CITY OF ALBUQUERQUE

RE: **Prima Entrada Lots 1-7**
9500 Sonterro Ave NW
Grading and Drainage Plan
Engineer's Stamp Date: 2/8/19
Hydrology File: J09D020A

Based on the submittal received on 2/11/19, this Grading and Drainage Plan cannot be approved until the following are corrected:

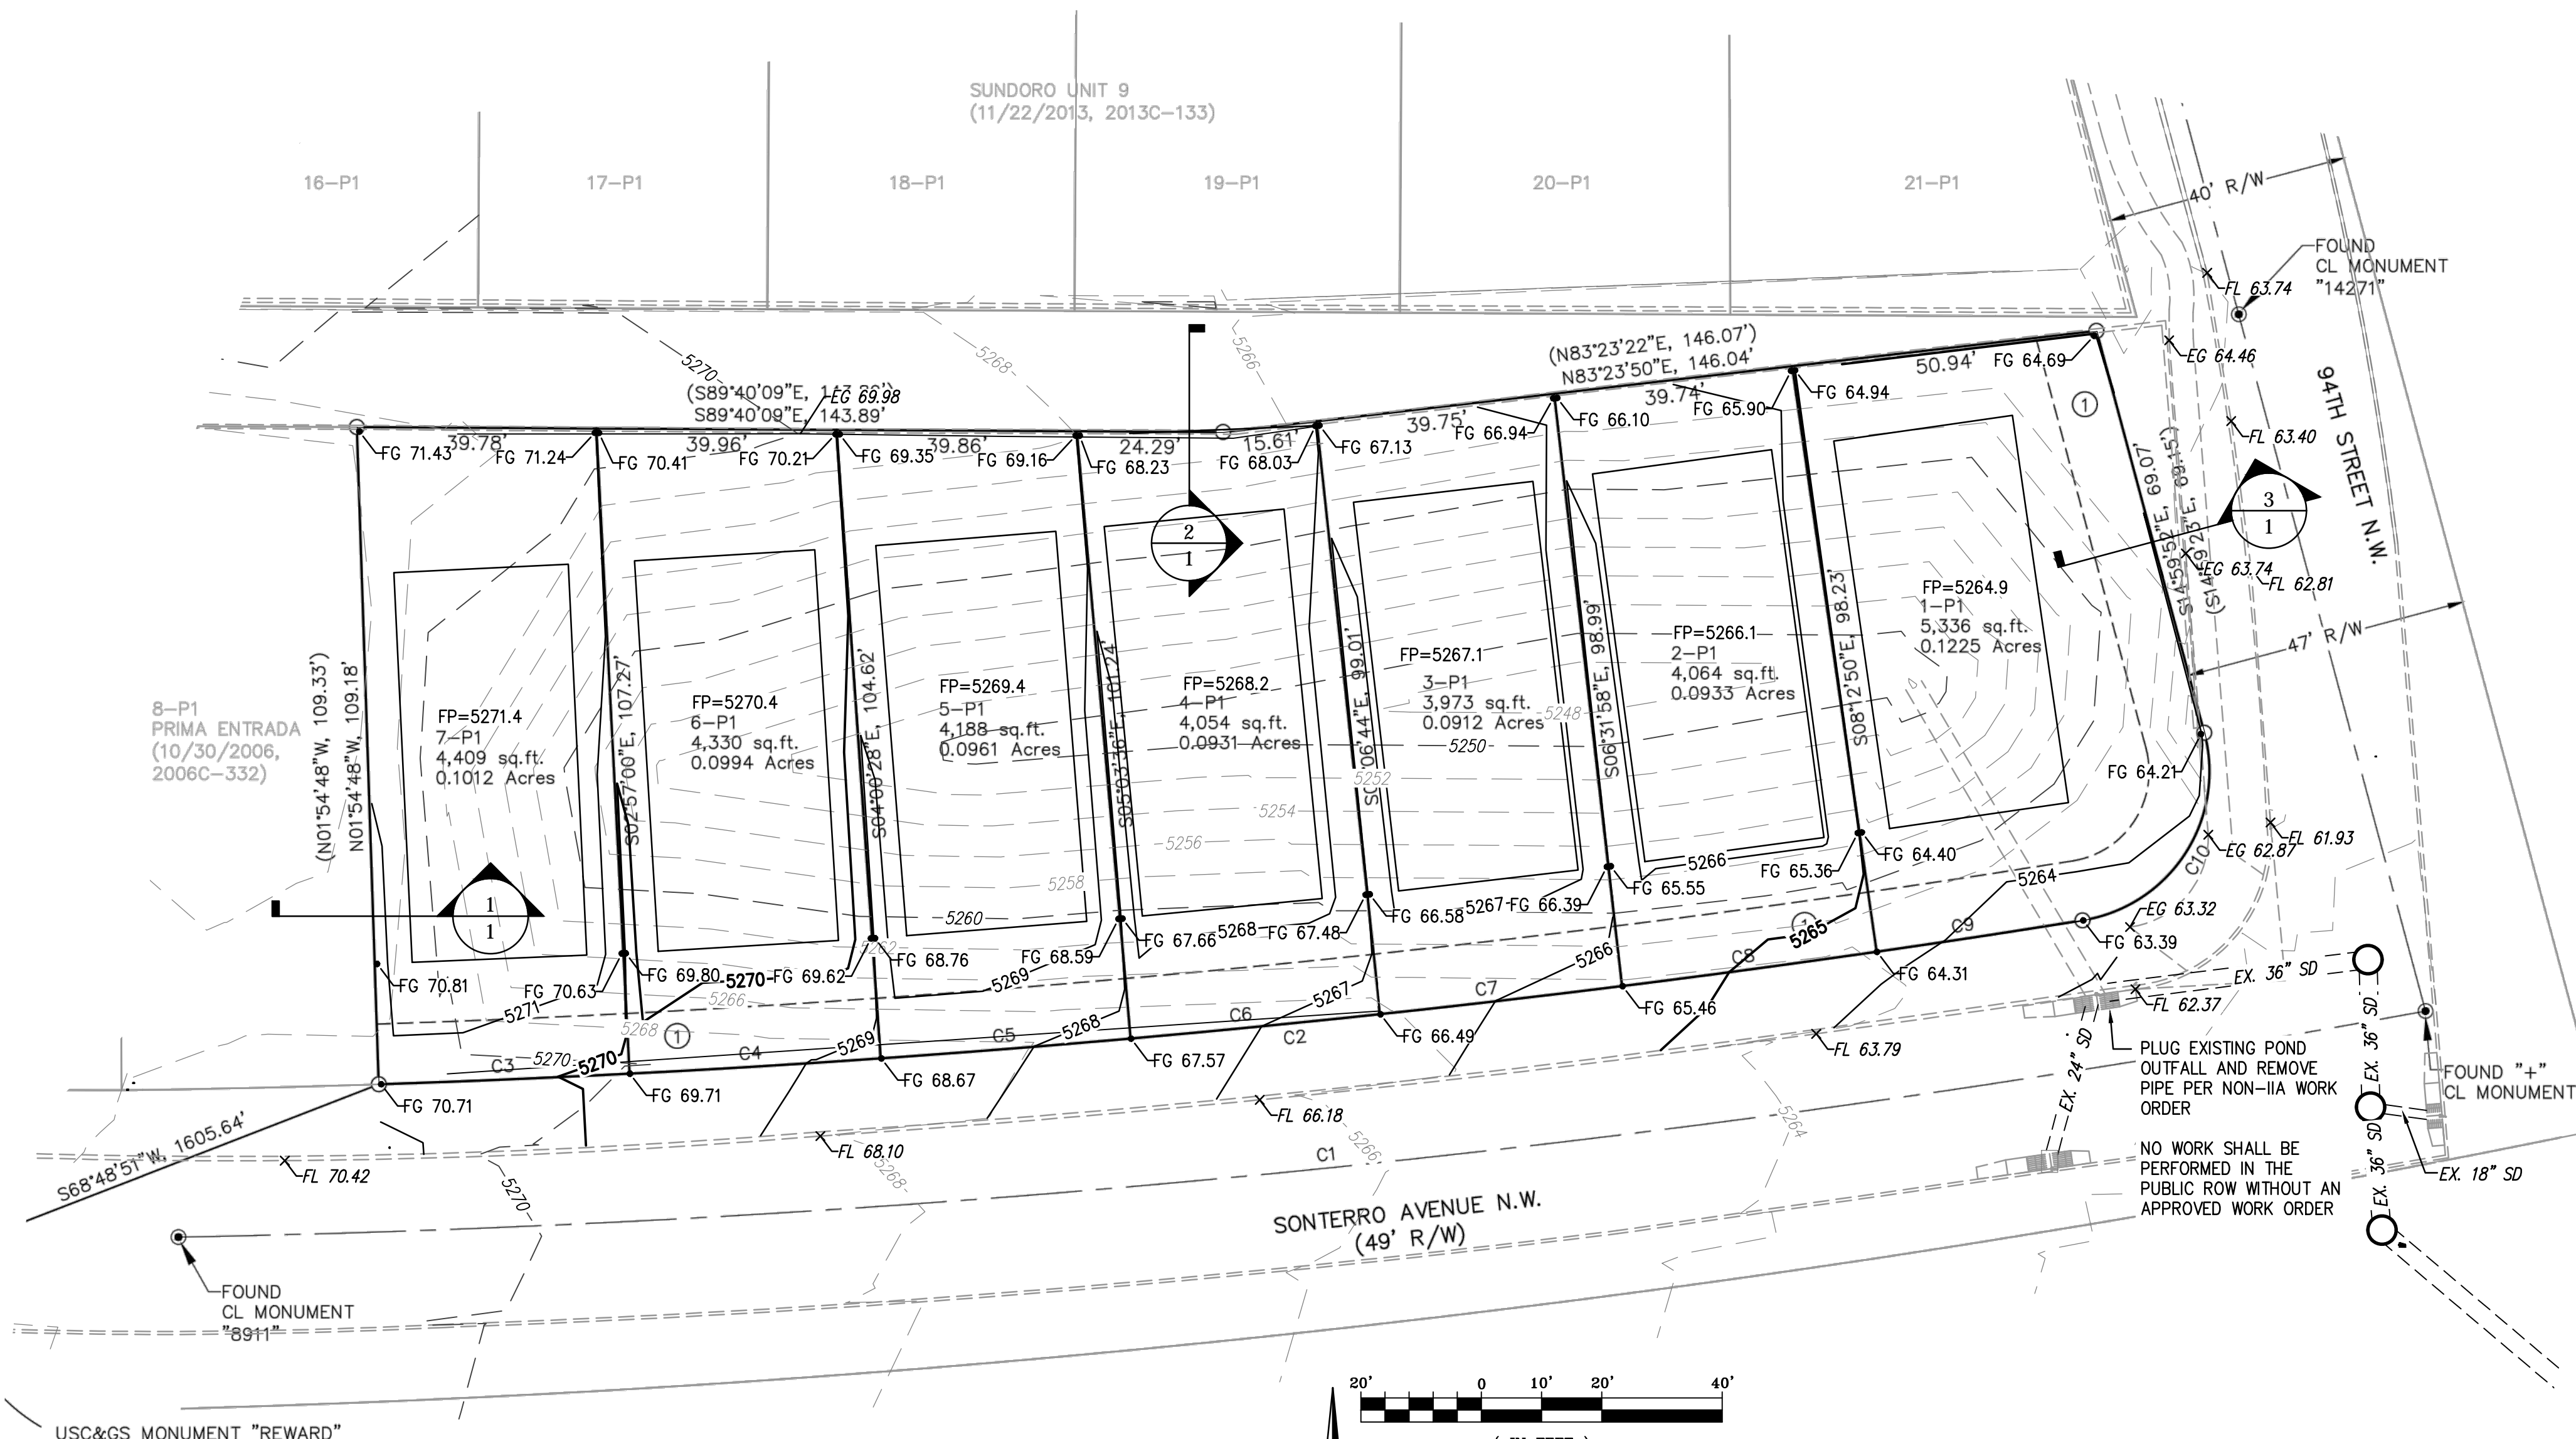
1. The site must demonstrate adequate downstream capacity per § 14-5-2-12(G) of the Albuquerque Code of Ordinances:
 - a. Provide a recorded drainage easement for the storm drain through the undeveloped tract (legal description: Tr of Land Situate In Sec 16 & 17 T10N R2E within the Town of Atrisco Land Grant Cont 1.6035 Ac) between the 94th St ROW and the AMAFCA channel. The legal right to discharge across this property must be established prior to increasing the discharge through it.

- b. Provide hydraulic calculations and profiles for the storm drain network, calculated along the energy grade line; the 10-yr water surface elevation and velocity the channel may be used as the control surface.

2. Because of the size of the patch being made to the back of inlet, the work will need to be permitted and inspected through the non-IIA Work Order (formerly known as Mini Work Order) process. On the grading plan, note that the pipe removal, inlet repair, and unplugging of the storm drain shall be performed by non-IIA Work Order, and that no work shall be performed in the public ROW without an approved Work Order. The non-IIA Work Order will need to include structural details for replacing the steel in the back of the inlet. Please contact Jeanne Wolfenbarger (jwolfenbarger@cabq.gov) if you need more information on this process.

3. Provide sections through all external boundaries showing proposed retaining walls, garden walls, property/ROW lines, existing and proposed grades. In accordance with DPM Ch.22, section 5 part B, grading and wall construction near the property line may not endanger adjacent property or constrain its use.
4. Identify internal retaining walls to be constructed by the developer (prior to Pad Cert) and those to be deferred to homebuilder. Any wall retaining 2 feet or more will need to be constructed by the developer (i.e prior to Pad Cert); less than 2 feet retained can be deferred to homebuilder.
